Subject: 2025/90439 Church of the Holy Innocents, Vicarage Road, Dewsbury, WF12 9PD

2025/90439 FORMER CHURCH of HOLY INNOCENTS, DEWSBURY WF12

Matthew Saunders
ECCLESIASTICAL CASEWORKER
Historic Buildings and Places
www.hbap.org.uk
Formerly Ancient Monuments Society

Project/Client:	Project No:
Church of Holy Innocents	22-111
Vicarage Road	Dwg No:
Dewsbury, WF12 9PD	A16
	Rev:
	A
Drawing:	Scale:
G.A. Information	1:100 @A1
Elevations As PROPOSED (sht 2 of 2)	Drawn By: Date:
Rear & Side Elevations	Checked By: Jun 23

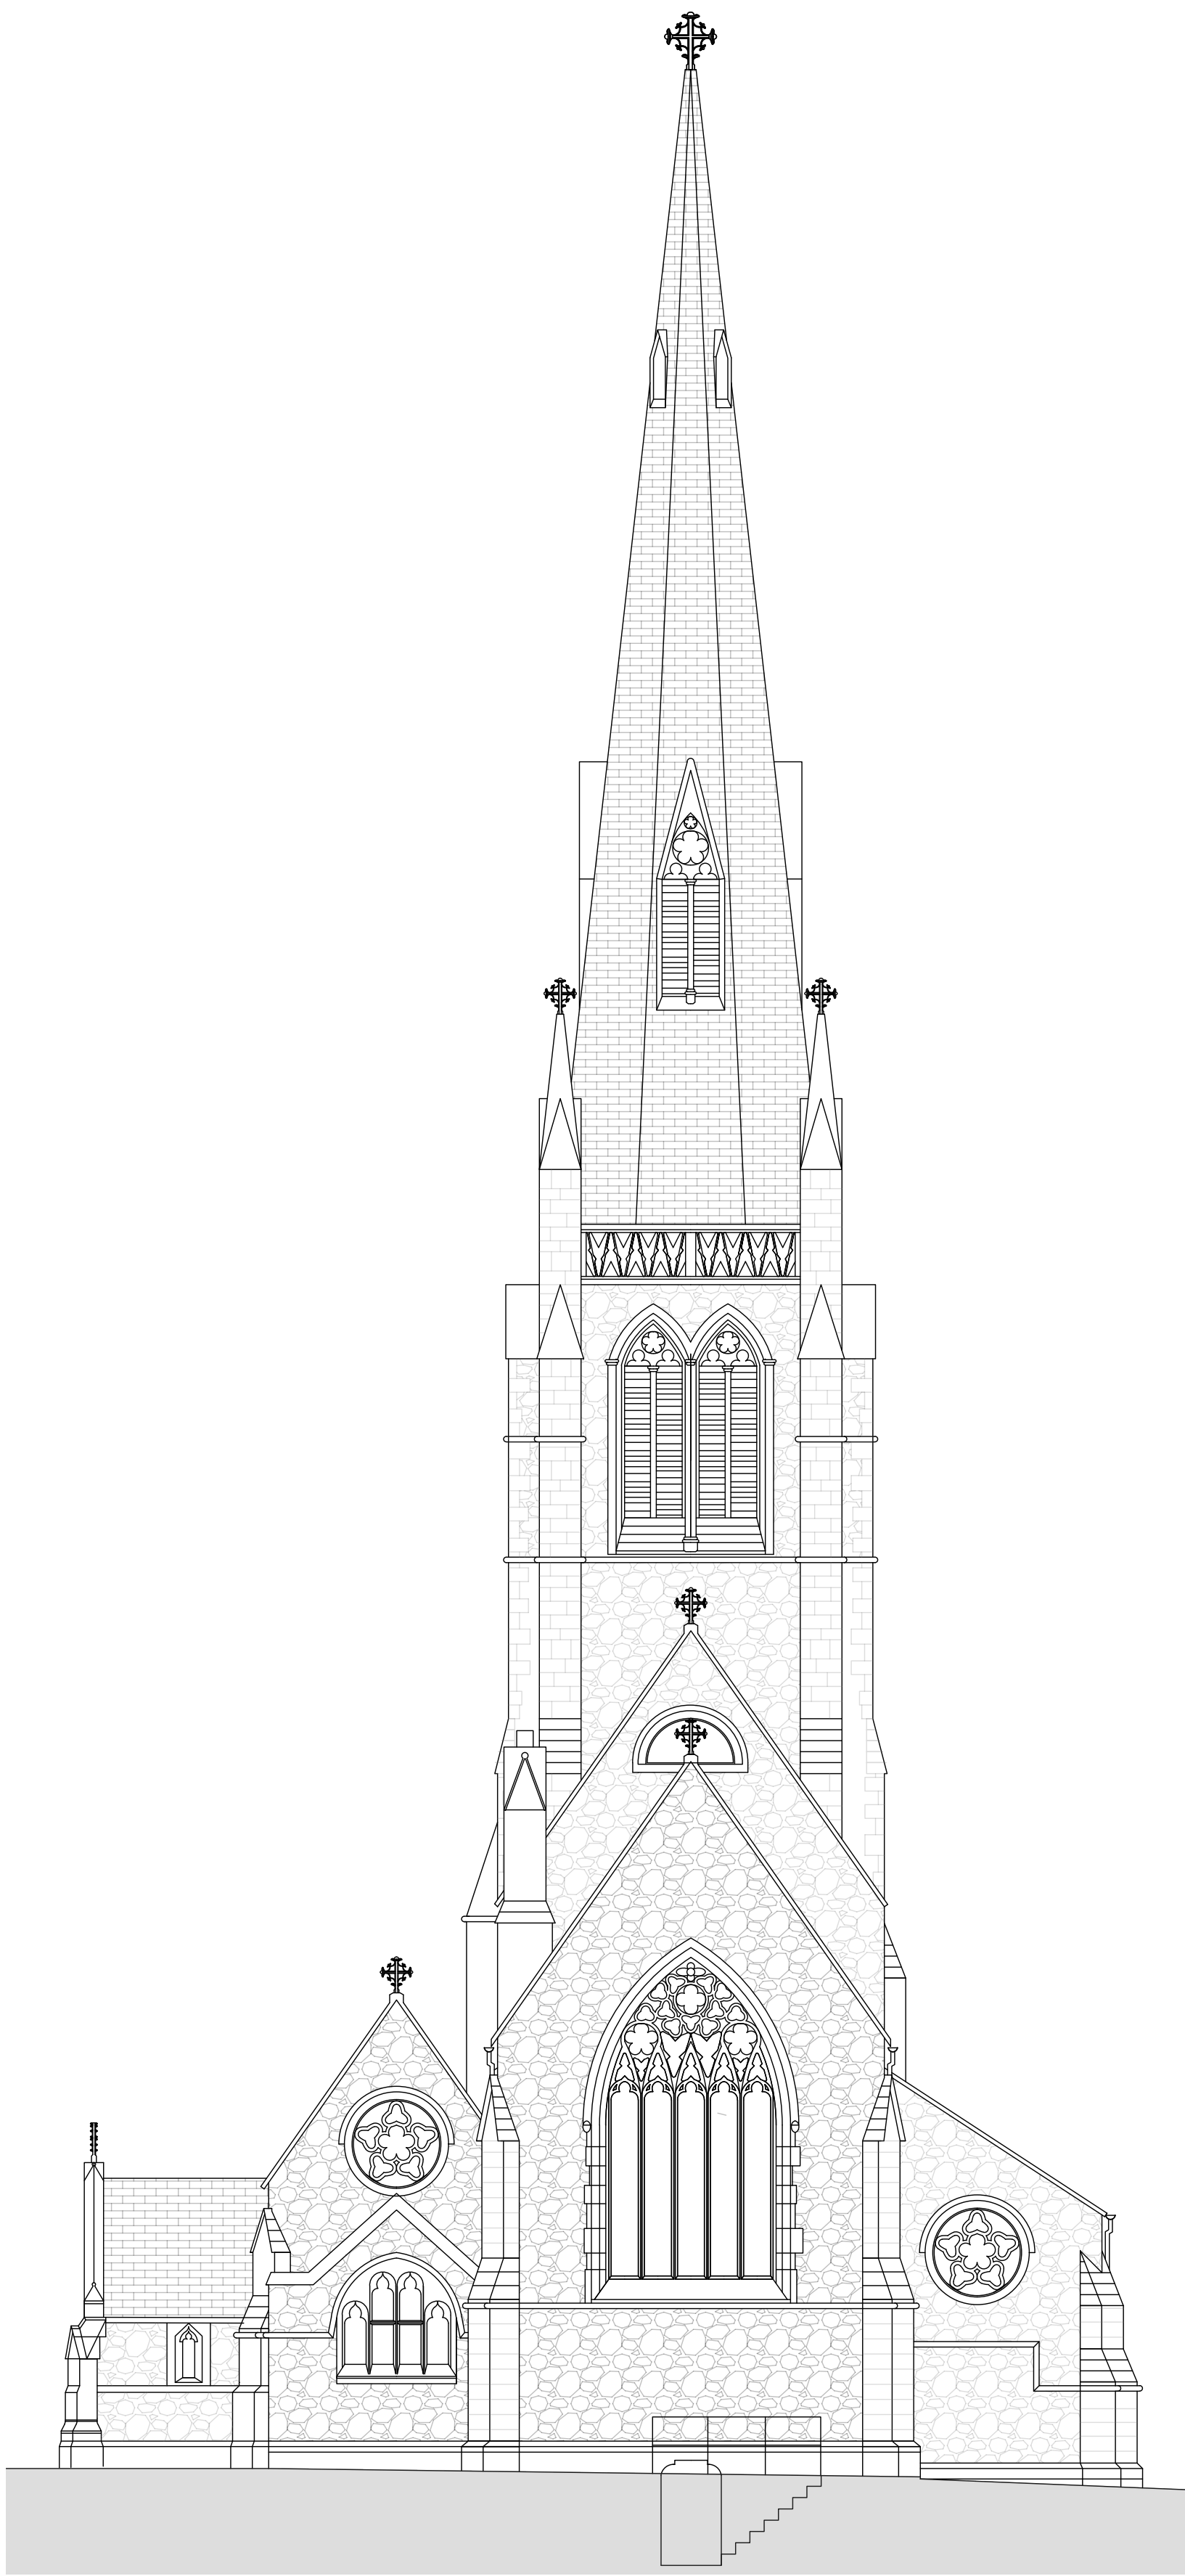
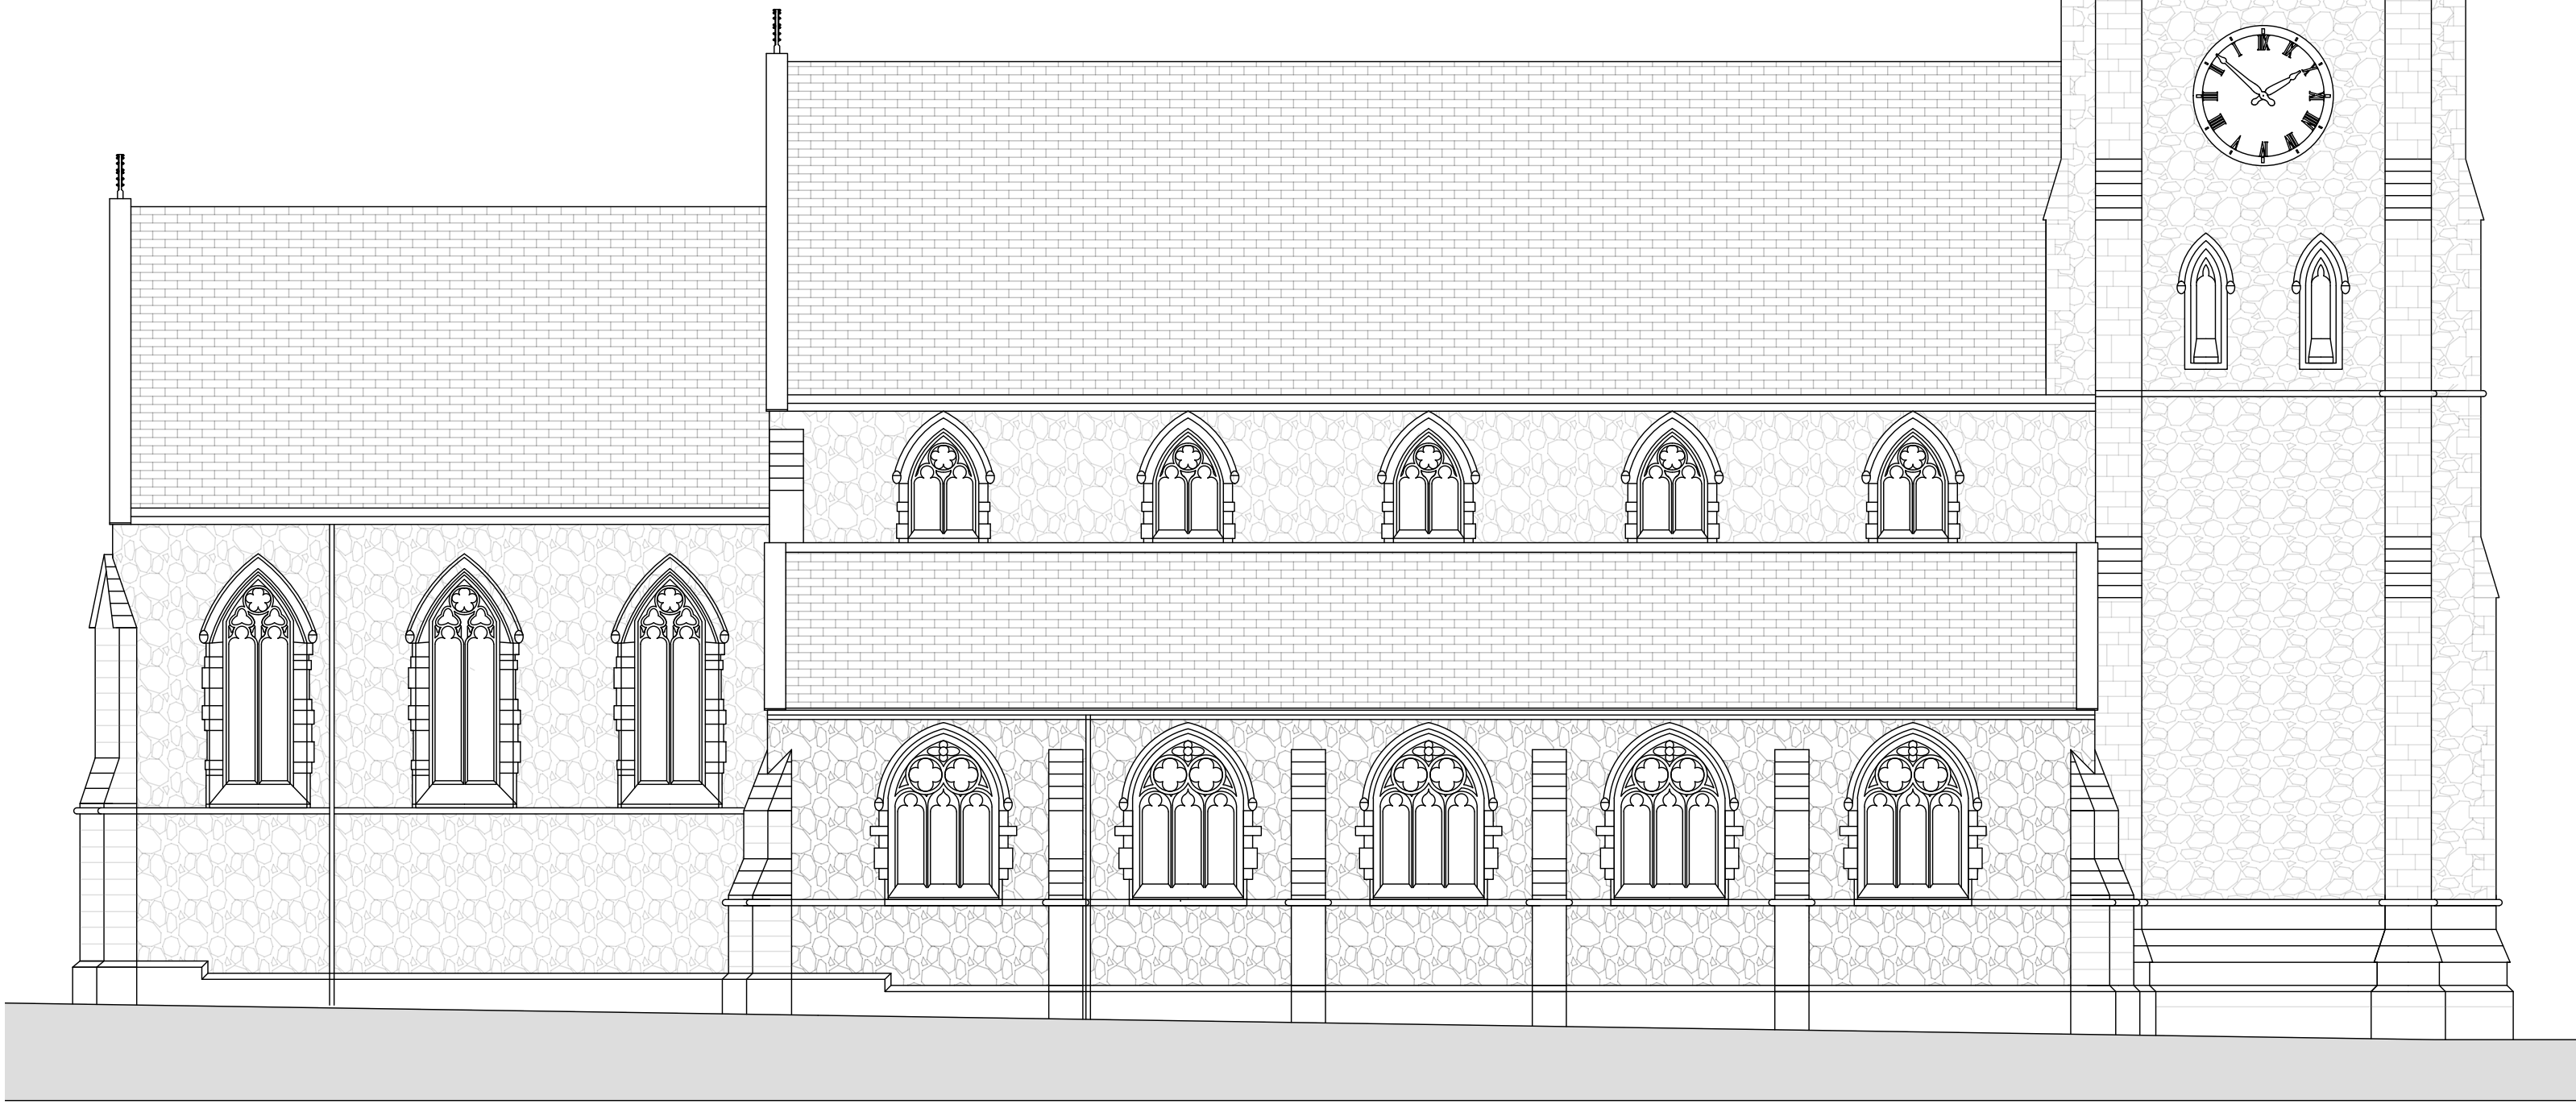
- a) The external rooflights have been reduced in number from 46 to 8
- b) The top (3rd) floor has been dropped (although I see that Drawing A14 still refers to “Future 3rd Floor Level”)
- c) The omission of the 2nd floor ceiling will reveal more of the fabric.
- d) The preparation of a precise list of fittings to stay now includes the bells and clock, the stained glass (on which see below), the tiled dados and wainscotting, the heating grilles, the memorial plaques, the font and the tiles in the baptistery, the pulpit, the organ casing (but not the majority of the pipes ?), and the external doors (albeit resited)
